Rezoning Petition Review

Date of Review: July 10, 2008 (**Revised August 20, 2008**)

Rezoning Petition #: 08-125

Location of Property: Approximately 70.91 acres located on the southwest quadrant of the Mt. Holly Rd. / I-485 Interchange

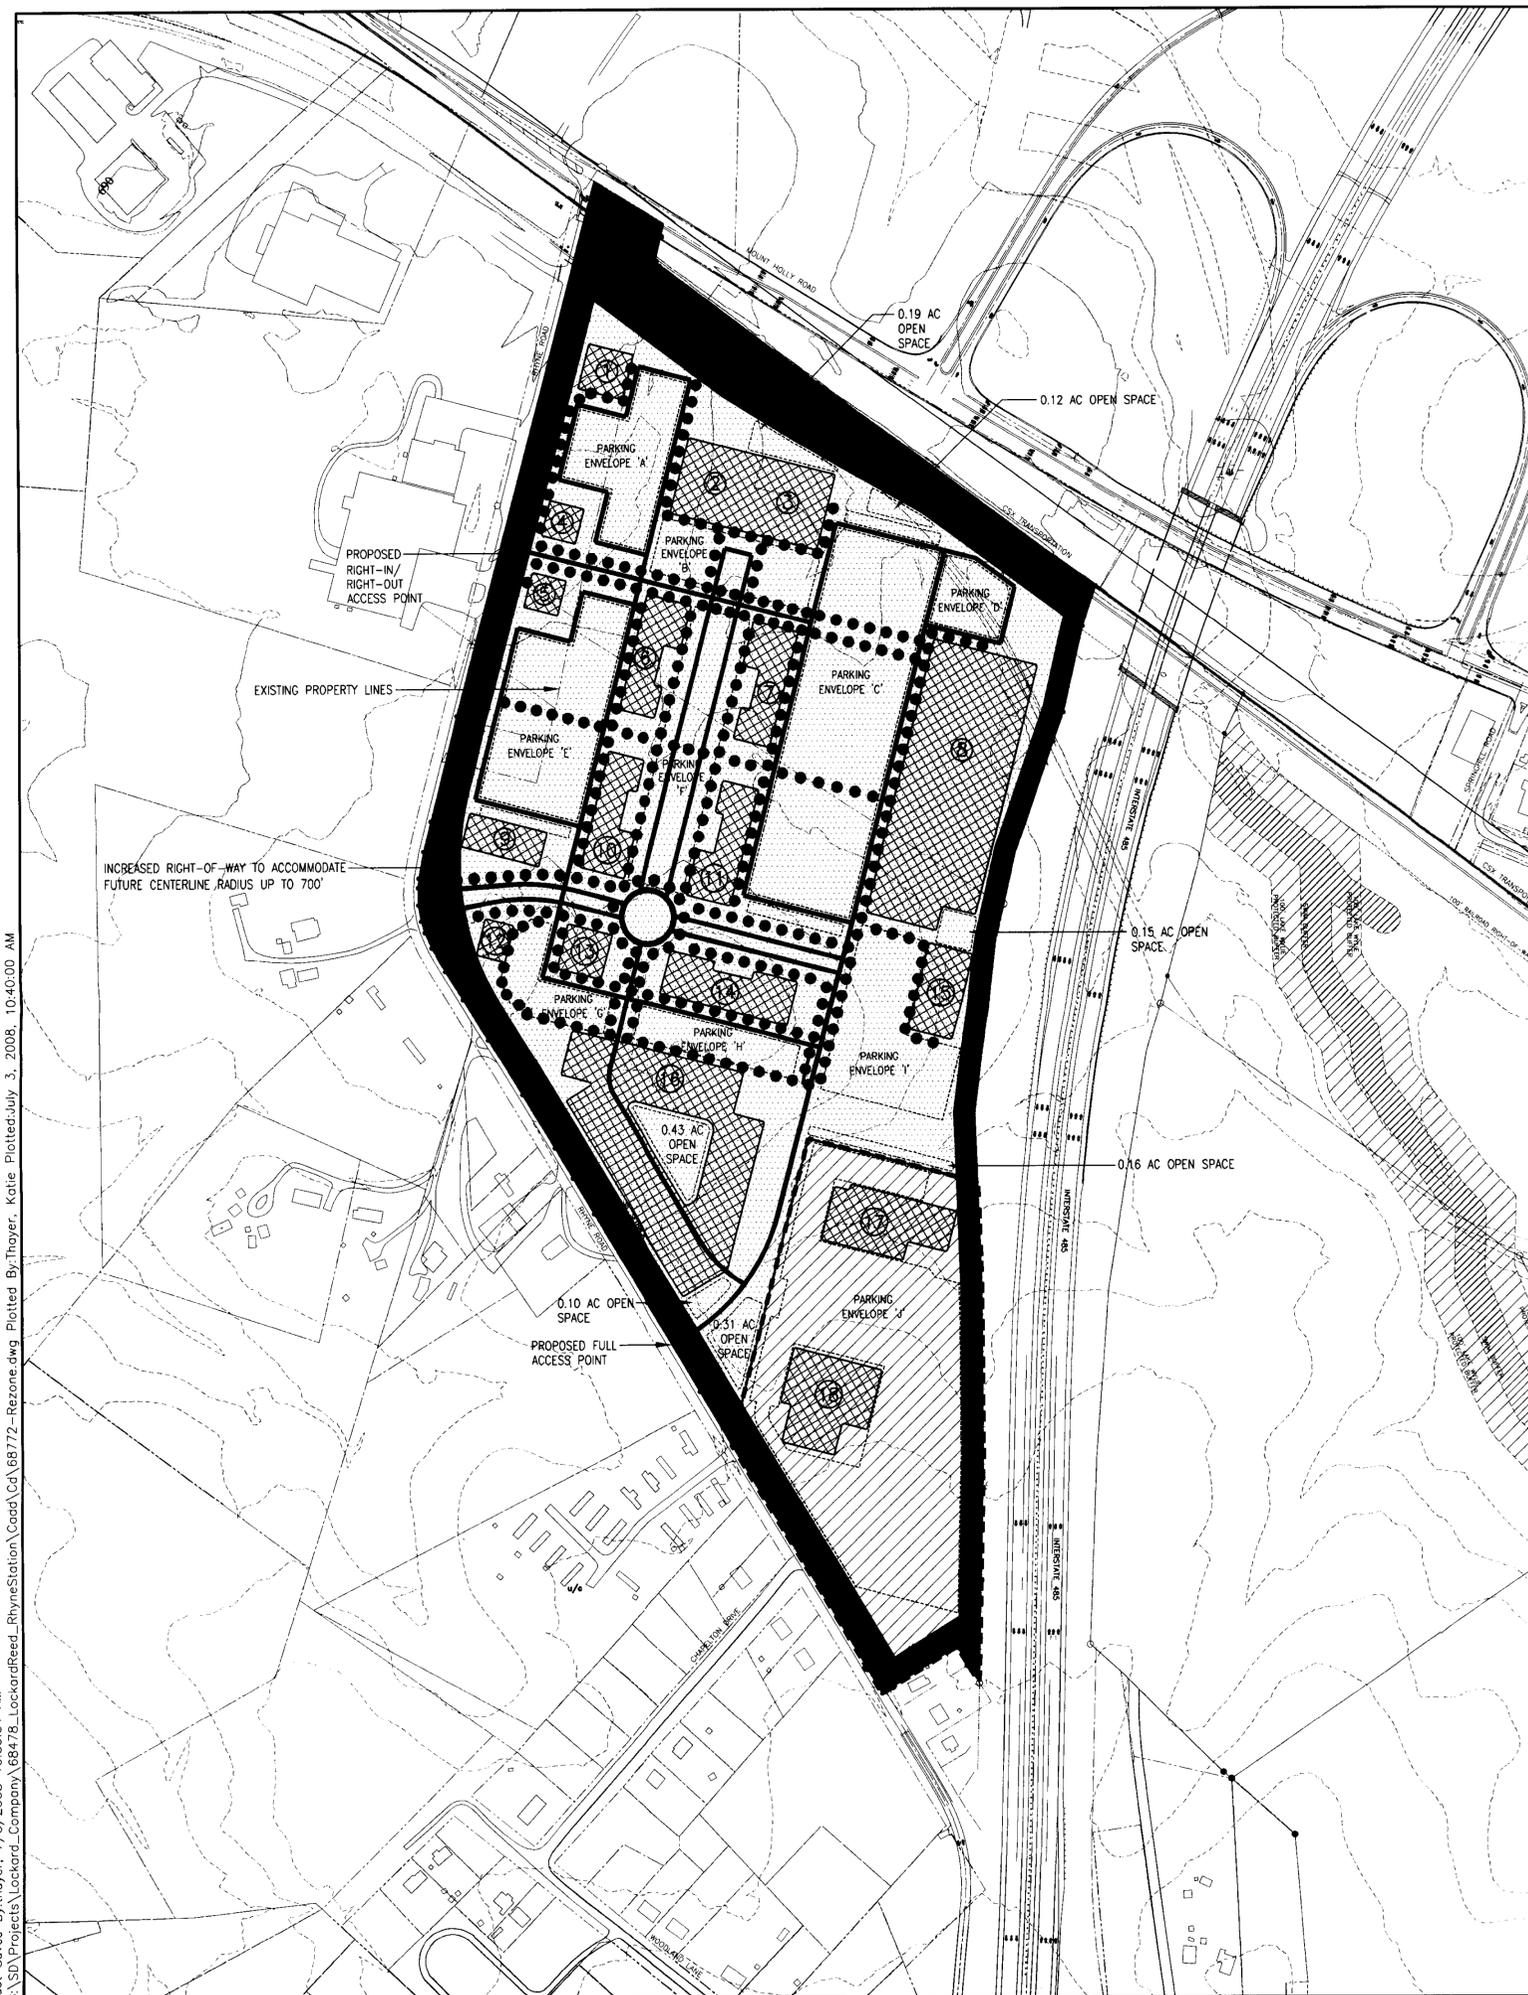
Recommendations Concerning Storm Water: **Please remove Storm Water Management notes and replace with the following note**

The petitioner shall comply with the Charlotte City Council approved and adopted Post Construction Controls Ordinance.
